From: Amanda Scholes on behalf of Planning.Responses
Sent: 06 December 2017 08:30
To: Planning Scanning
Subject: FW: Y/52/17/DOC - Longacre, Maypole Lane

Further Drainage comments

I still have Condition 03 (surface water drainage) outstanding on this application.

Lavender Cottage Drainage Plan
Scale 1:100

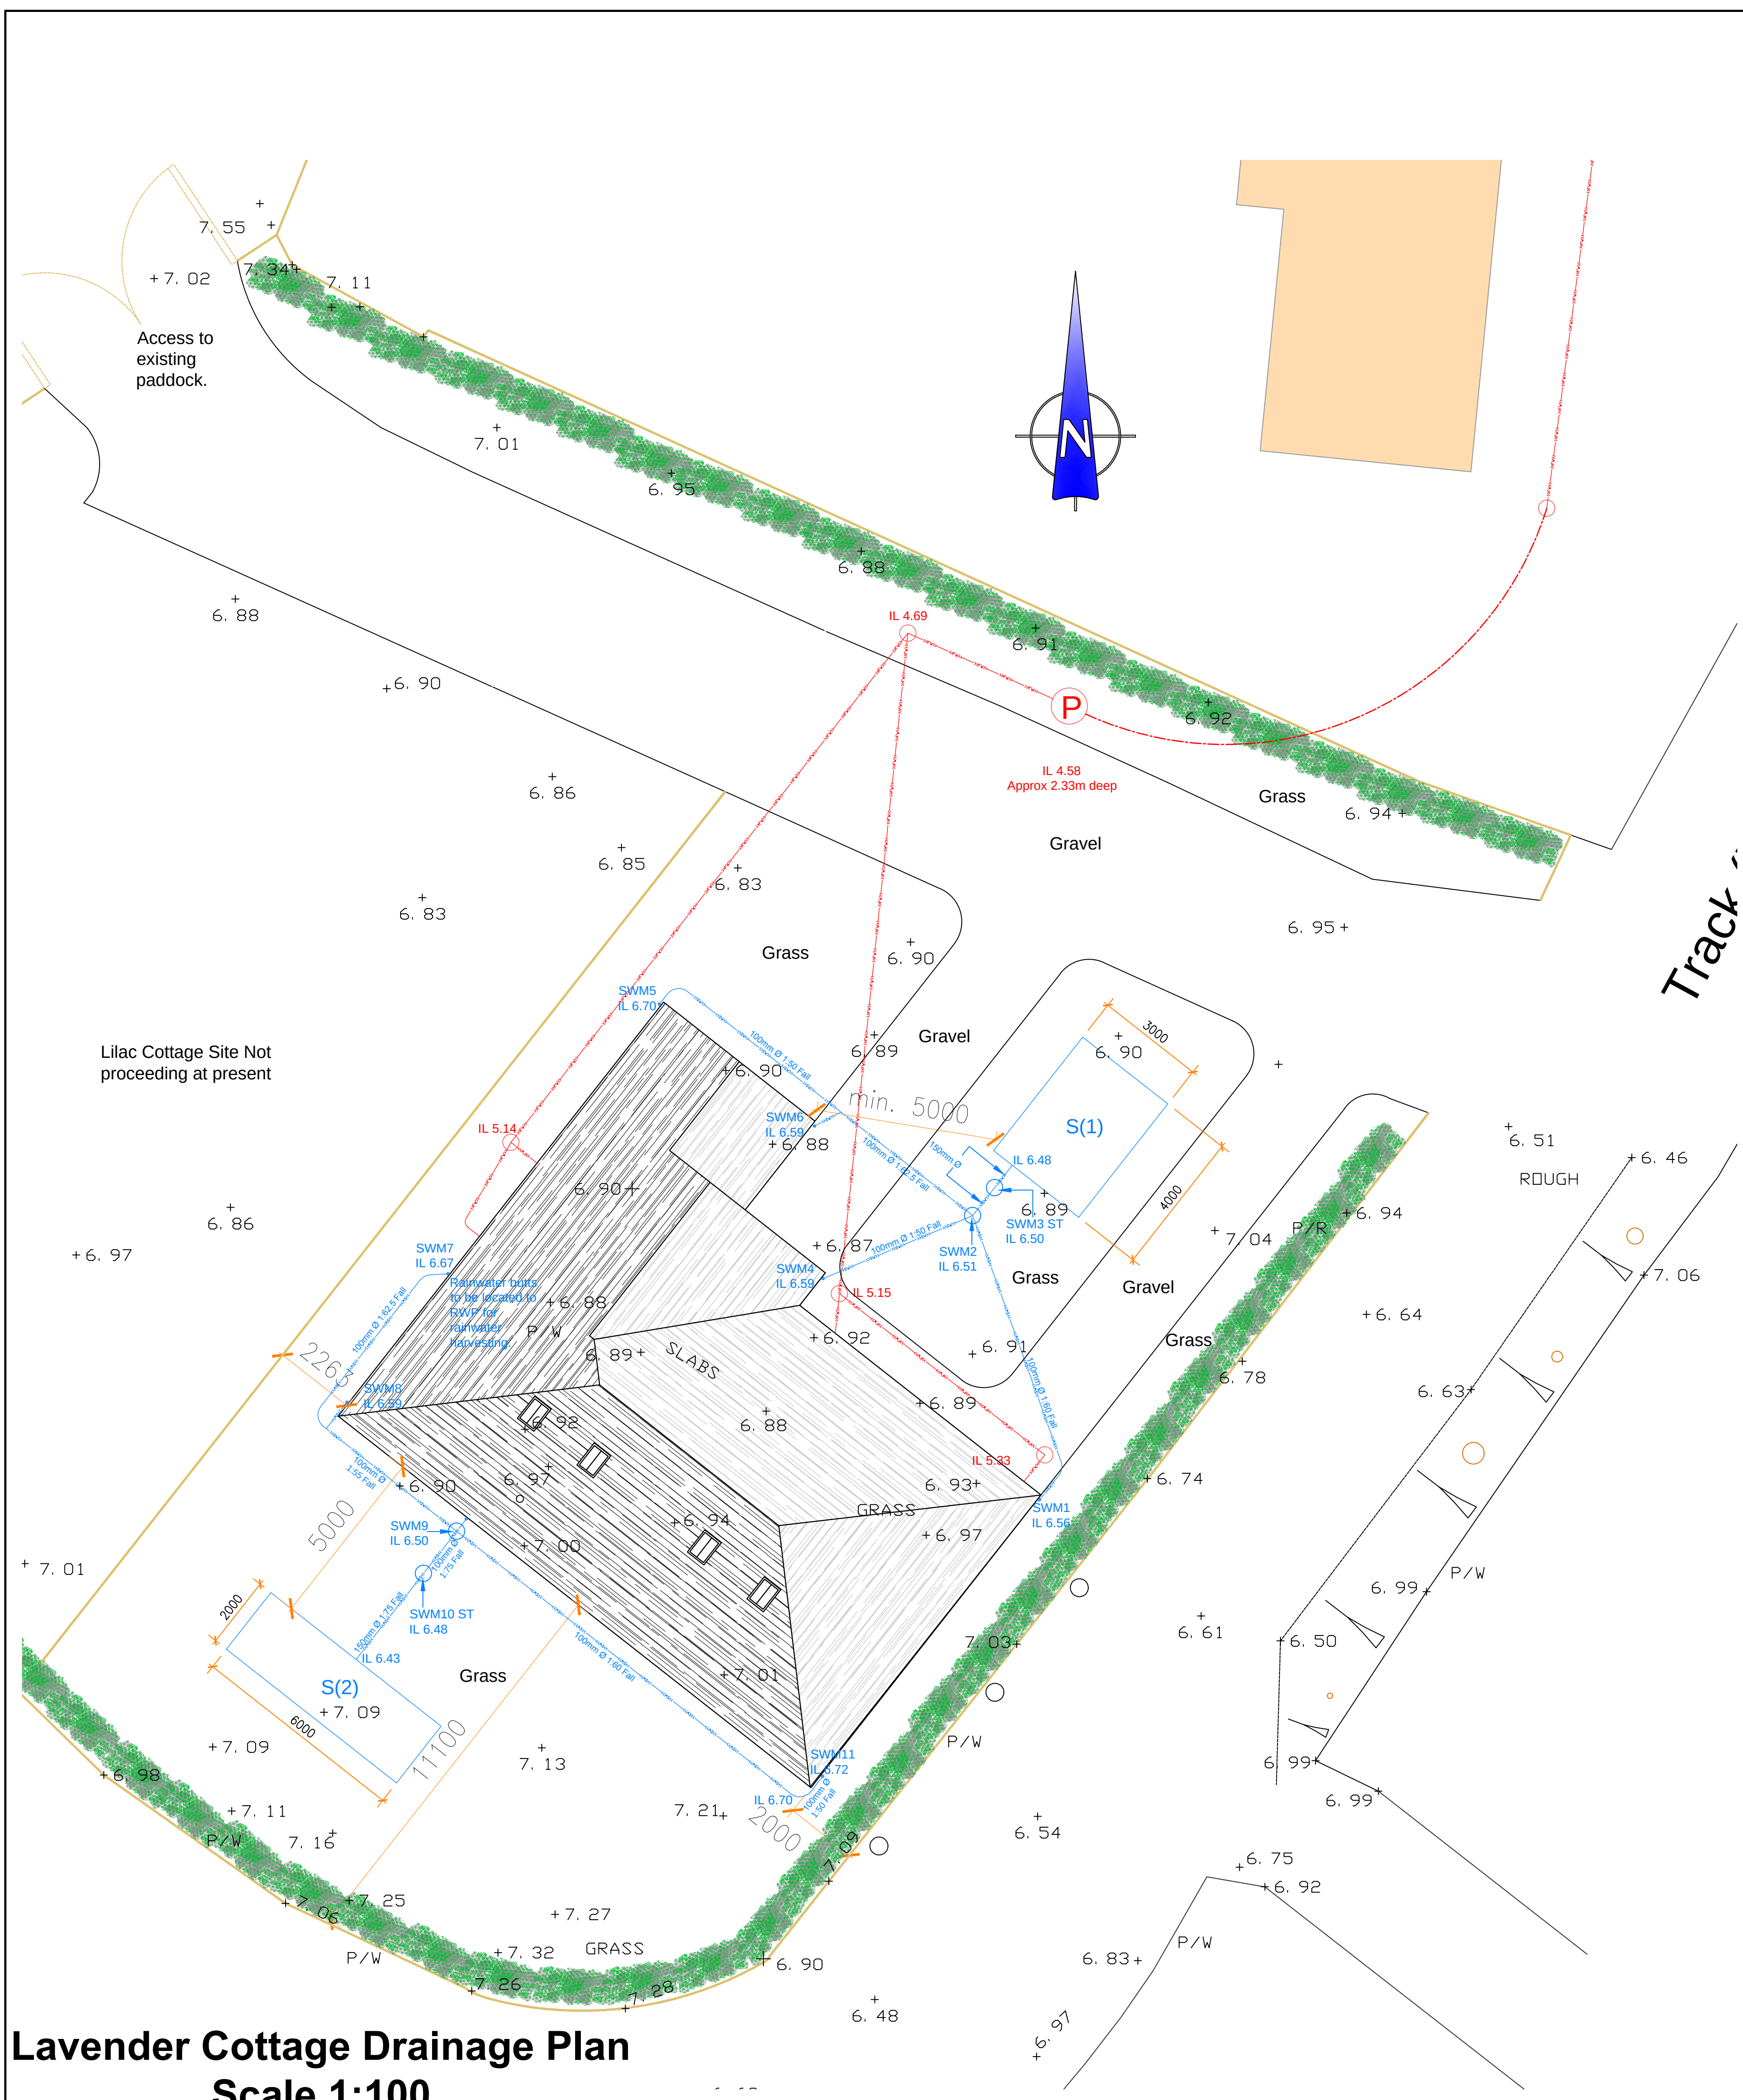
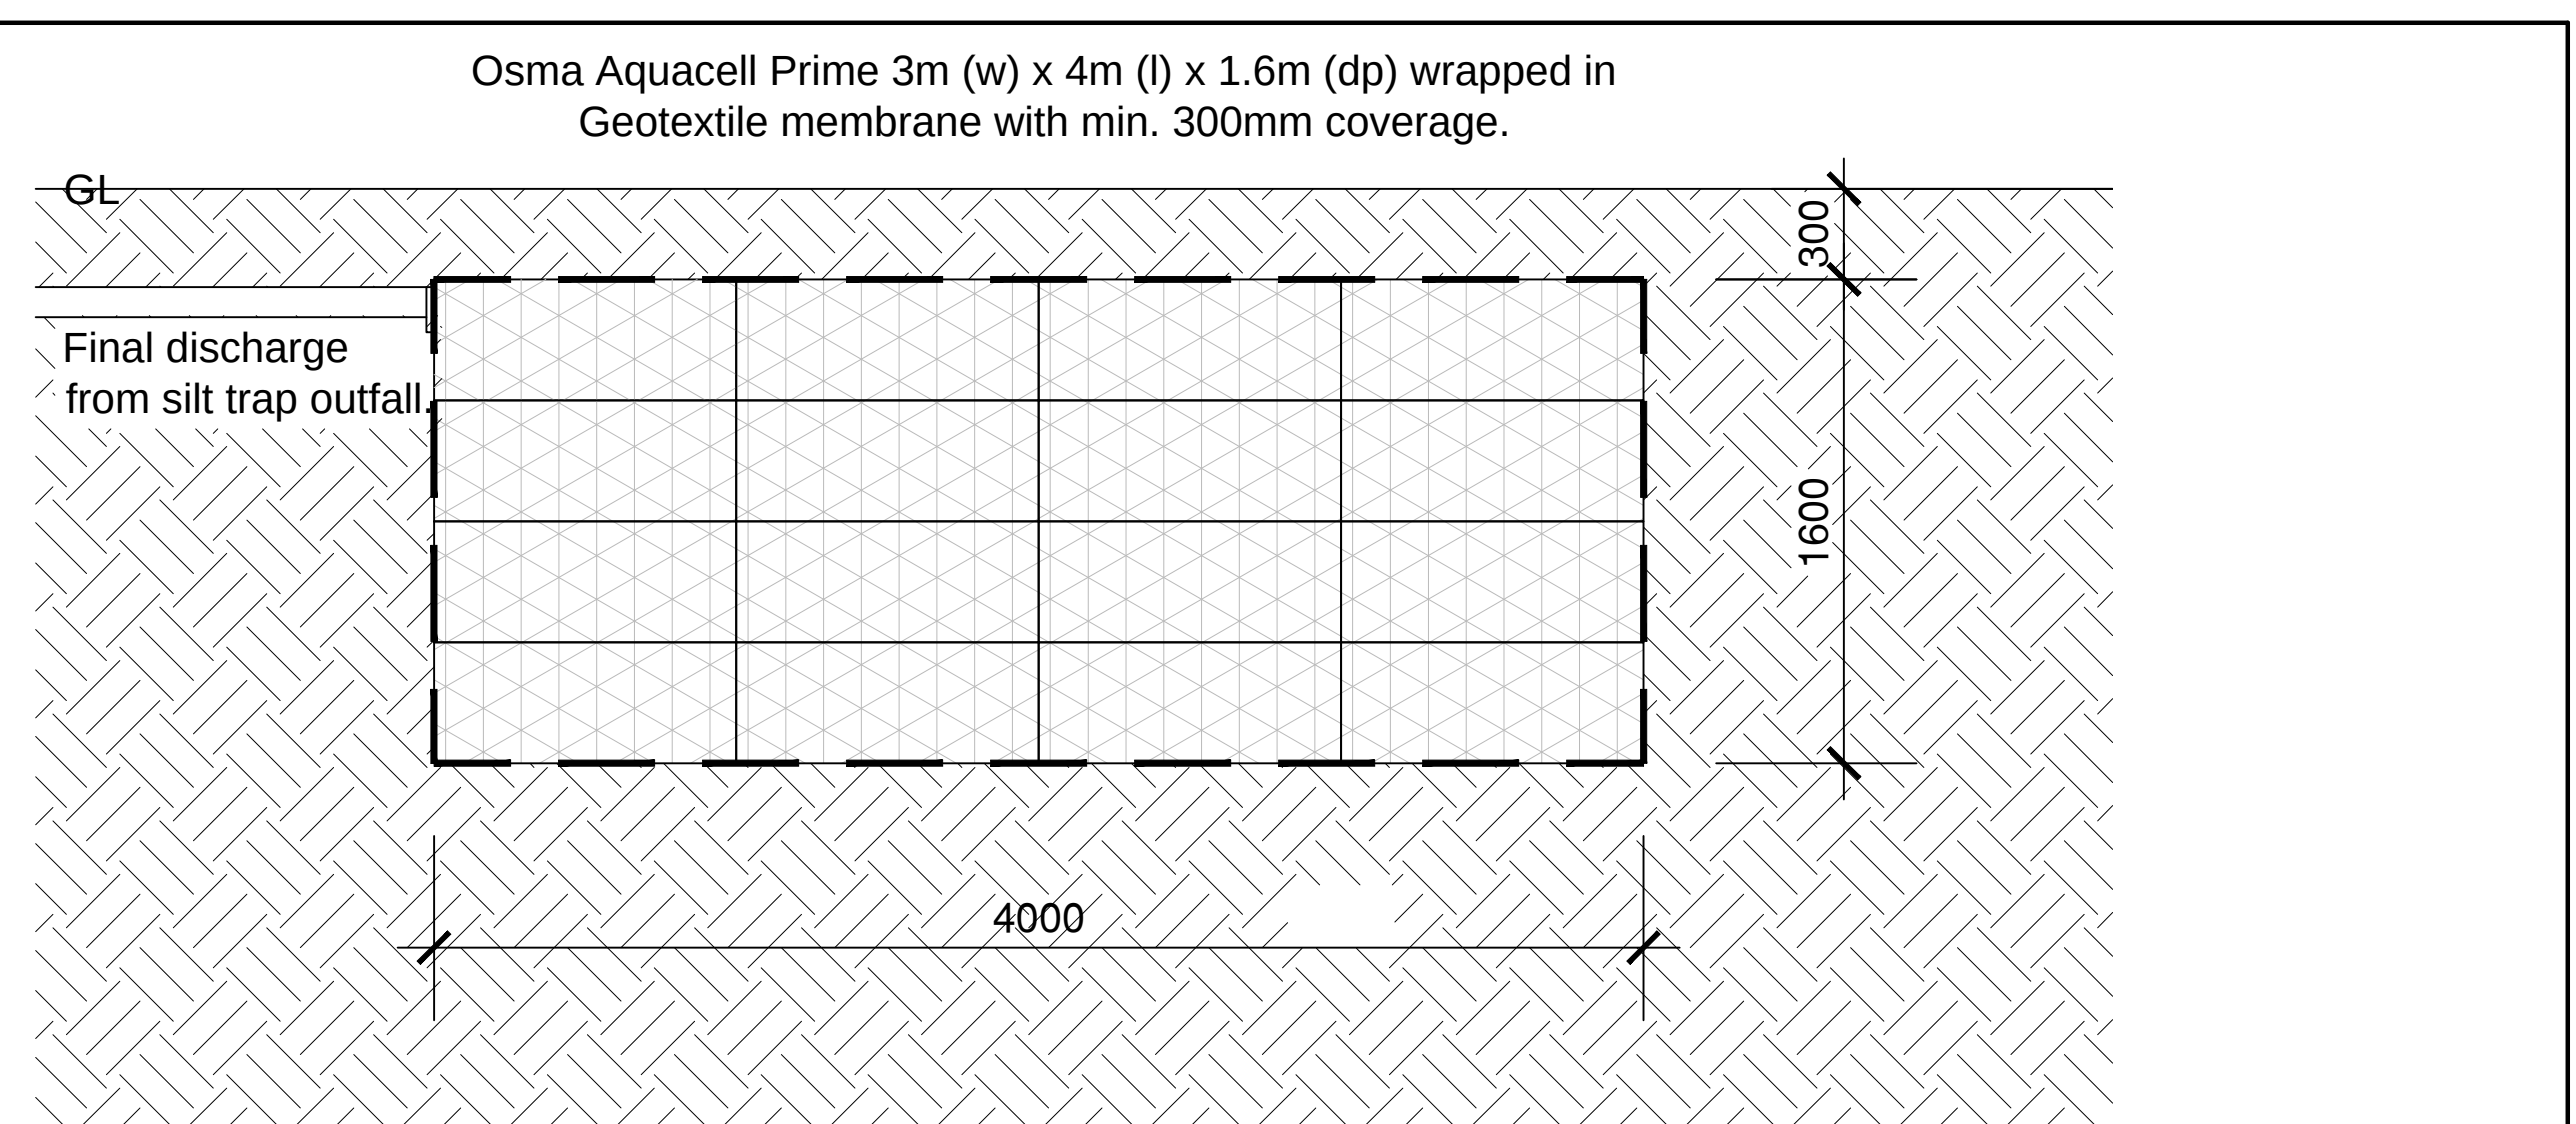
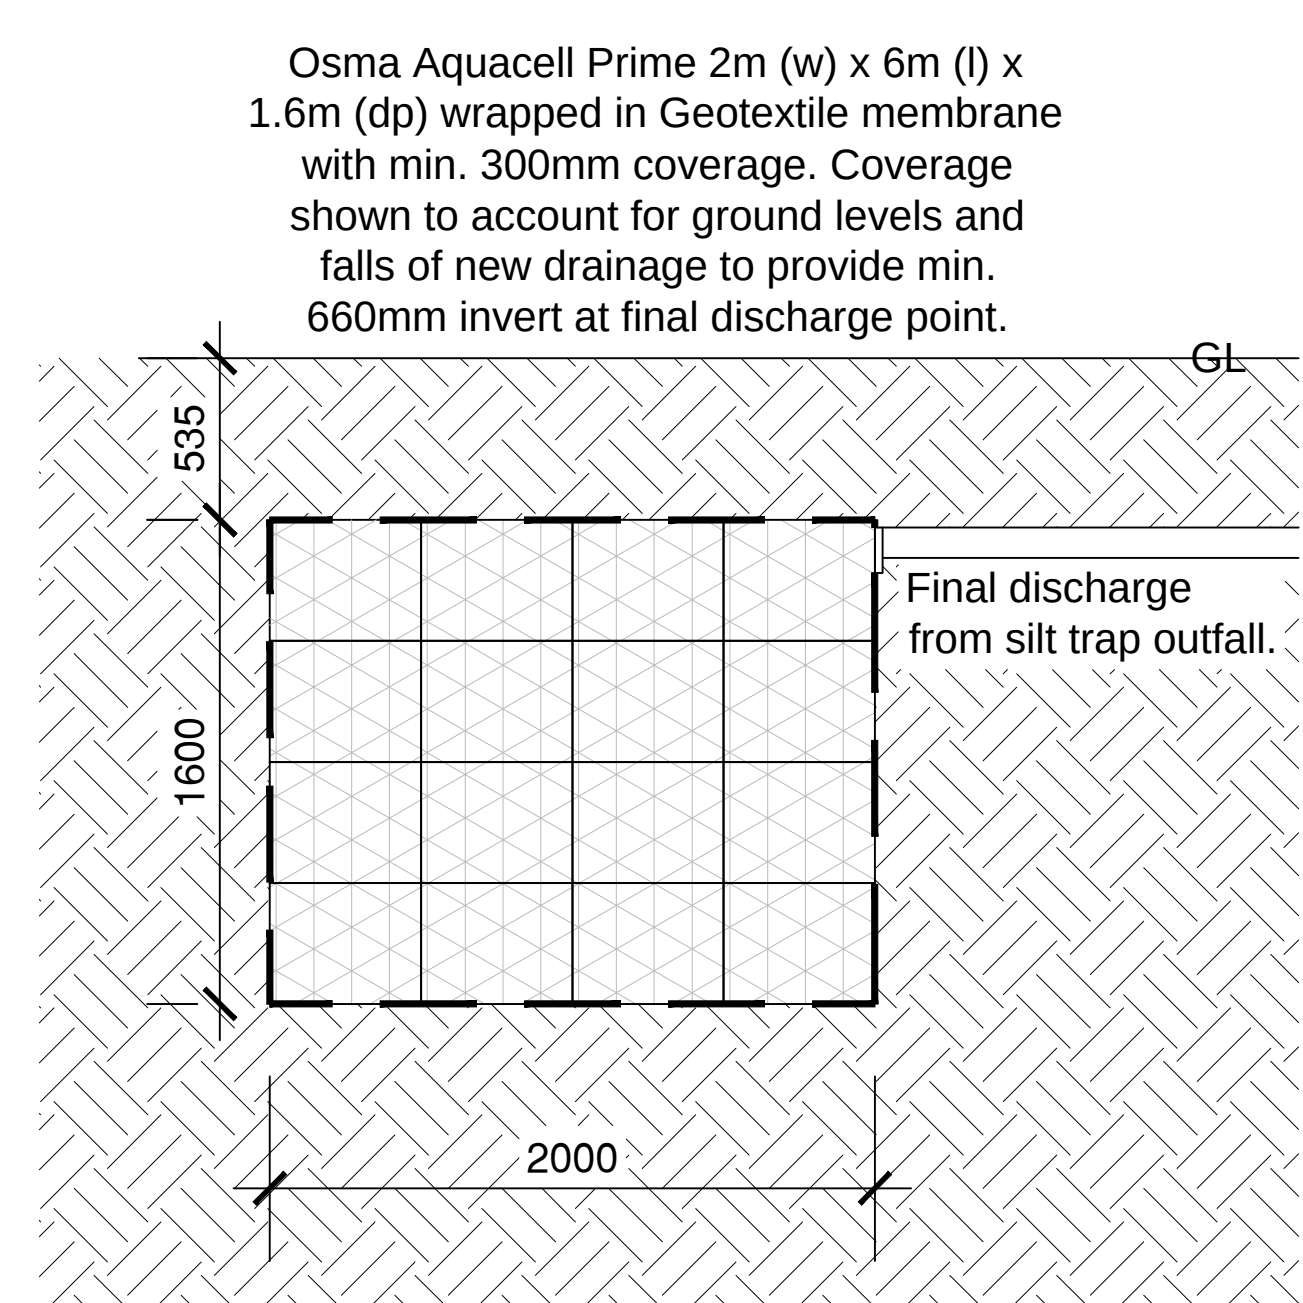
1. Please provide a clean copy of the stormwater drainage design document dated Sept 17, as the scanned copy is unreadable in places.
2. Provide details of the groundwater level observations in Feb 2017.
3. Calculations need to include an allowance for climate change ie. 30%.
4. Page 2 of the Sustainable Drainage Management Plan appears to be missing.
5. Provide catchpit construction details.
6. Provide additional manhole on south west corner of building.
7. I note the driveways are to be gravel surfaced, however, they need to be designed to store the 1 in 100 year storm+30% within the sub base. Please provide construction details and calculations in this respect.
